Our Ref: 2007406
PINS Ref: EN010138
Enquiries to: Mark Woodger

**RIVENHALL EFW – IWMF EN010138
ESSEX COUNTY COUNCIL 2007406
ECC DEADLINE 3 SUBMISSIONS**

Please find set out below and attached Essex County Council's Deadline 3 submissions. These consist of the following:

Figure 8.1: Sensitive Receptor Locations identified in Condition 38

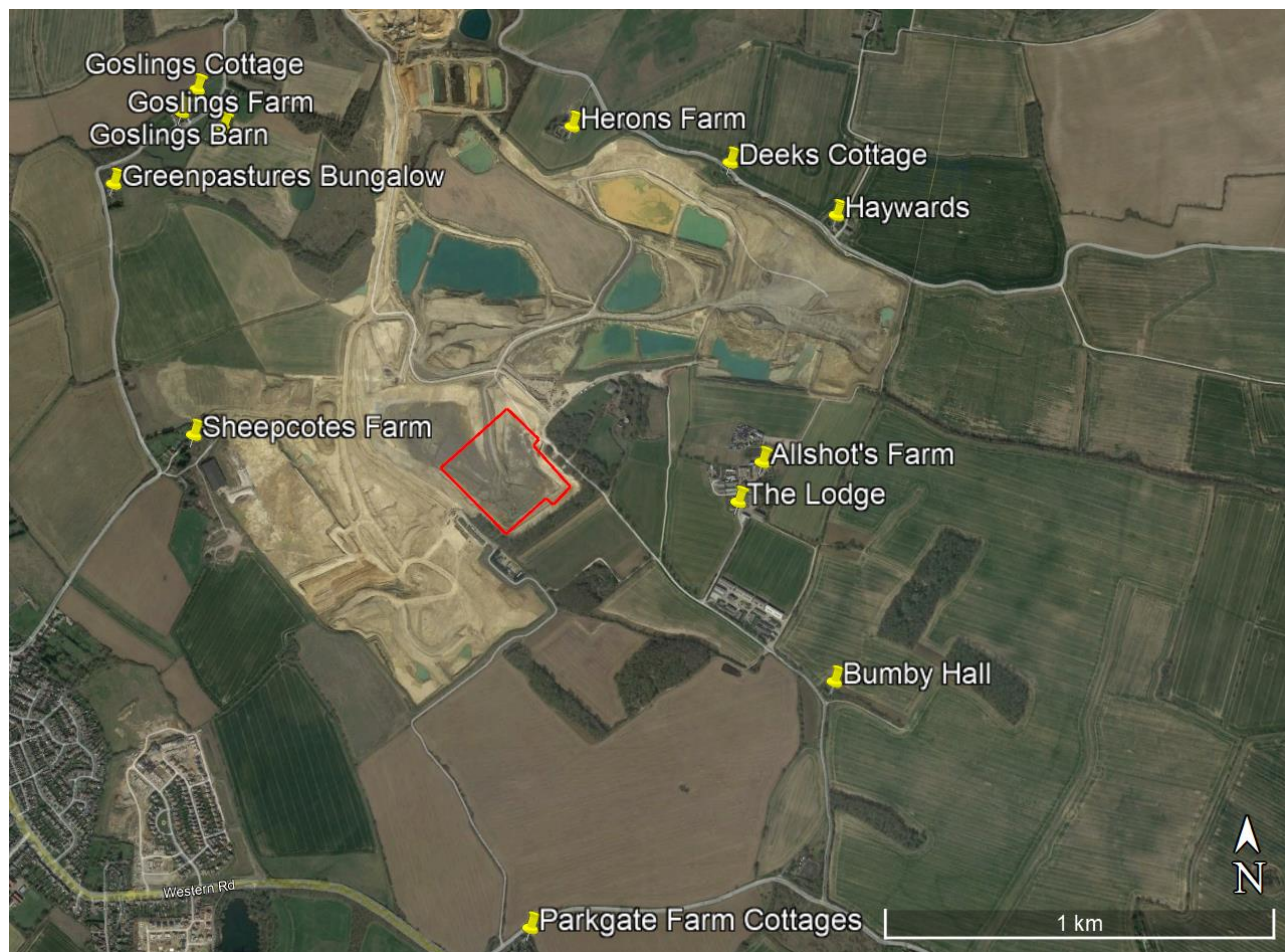
The Technical Memo has used a previous planning application for a change to operating hours for the DSM (ESS/20/17/BTE, 14 August 2018) in order to derive predicted DSM noise levels at 10 identified receptors including Heron's Farm, close to the DSM and The Lodge which is close to the IWMF. Bradwell Hall is identified as a DSM receptor in the planning consent but has not been modelled for the cumulative assessment. This receptor is close to the DSM, but further from the IWMF than Heron's Farm and is therefore not expected to experience cumulative effects at levels more adverse than Heron's Farm.

The Technical Memo then adds the DSM predicted noise levels to the IWMF noise levels and compares these cumulative noise levels with the existing consented IWMF noise limits. Notwithstanding our previous comments (August 23 and April 24) regarding the appropriateness of applying the previously consented IWMF noise limits to the current proposed applications, it is concluded that the predicted cumulative noise levels would meet these existing IWMF noise limits. It should be noted that the predicted cumulative noise levels for The Lodge are equal to the proposed noise limit.

It should also be noted that predicted DSM noise levels presented in the DSM application are 3 dB lower than the night-time noise limit imposed by the current Bradwell Quarry consent (39 dB vs 42dB LAeq 1 hr), and 5dB lower than the evening noise limit (44dB LAeq 1hr). Compliance monitoring undertaken for the DSM plant has been unable to confirm the exact site attributable noise levels due to the influence from extraneous noise. ECC would be unable to take any enforcement action if DSM noise levels increased above the predicted noise levels until the planning consent was

breached. Therefore, it would be prudent to consider whether the DSM operating at its consented limit would, in combination with the IWMF, cause a significant cumulative effect. For example, adding 3dB to the Technical Memo's predicted DSM noise levels would result in an exceedance of SLR's proposed night-time noise limit at The Lodge.

Figure 8.2: Predicted Daytime Specific Sound Level at Grid Height of 1.5m – dB(A)

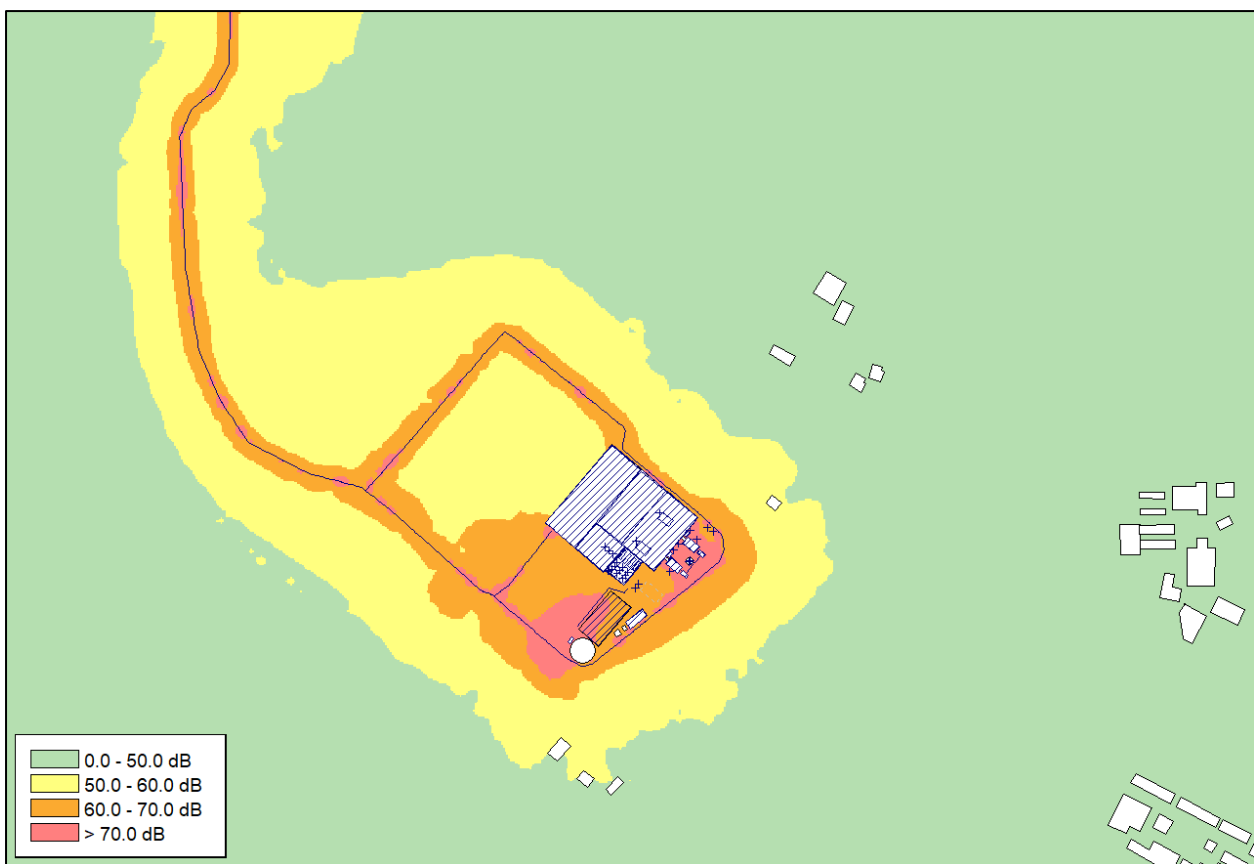
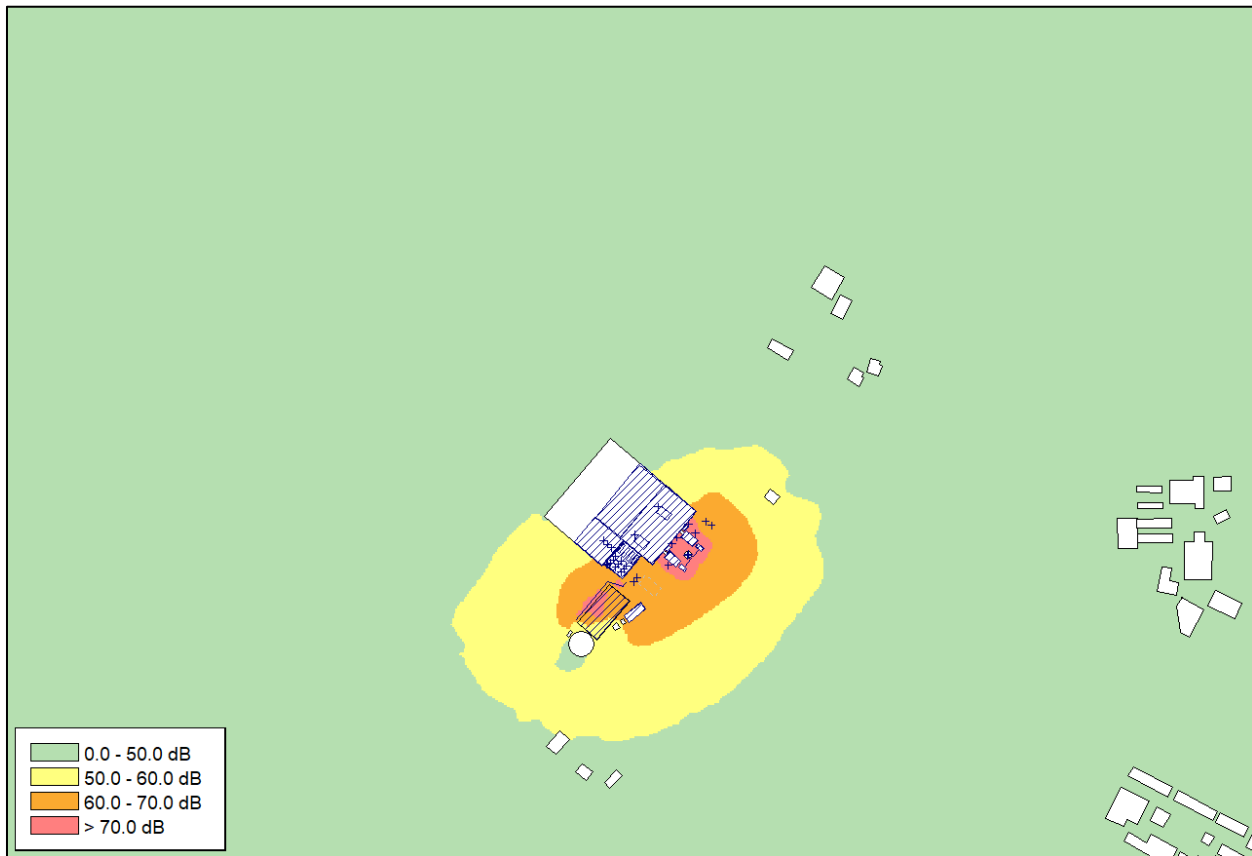
Therefore, a full review of the noise models has not been possible at this time due to the supporting data (which may include manufacturer datasheets, noise measurement data, internal room noise level calculations, etc.) not being made available. As such, it is not possible for Jacobs to confirm the veracity of the predicted noise levels presented in the ES chapter.

Despite the lack of the supporting data that had been previously requested by Jacobs, it has been possible for some checks to be completed regarding the propagation of noise from the site to the noise receiver at the various noise sensitive receptors and a number of comments have been raised. We would recommend that SLR consider the comments and then review the settings / approaches adopted, as appropriate, to confirm that they represent reasonable worst-case conditions. The most pertinent comments that may be contributing to an under prediction of noise levels are:

- The level of reflection that has been assumed from the surfaces of buildings within the model.
- Noise source directivity, particularly if there are examples of noise source propagation from sources to receivers that are on-axis and consequently more likely to result in an increase in prediction noise level at receivers.

There are also potential sources of noise over prediction identified in the review, such as the receiver height at The Lodge (worst-affected receptor) at night and the omission of source directivity for noise sources where the noise propagation path is off-axis.
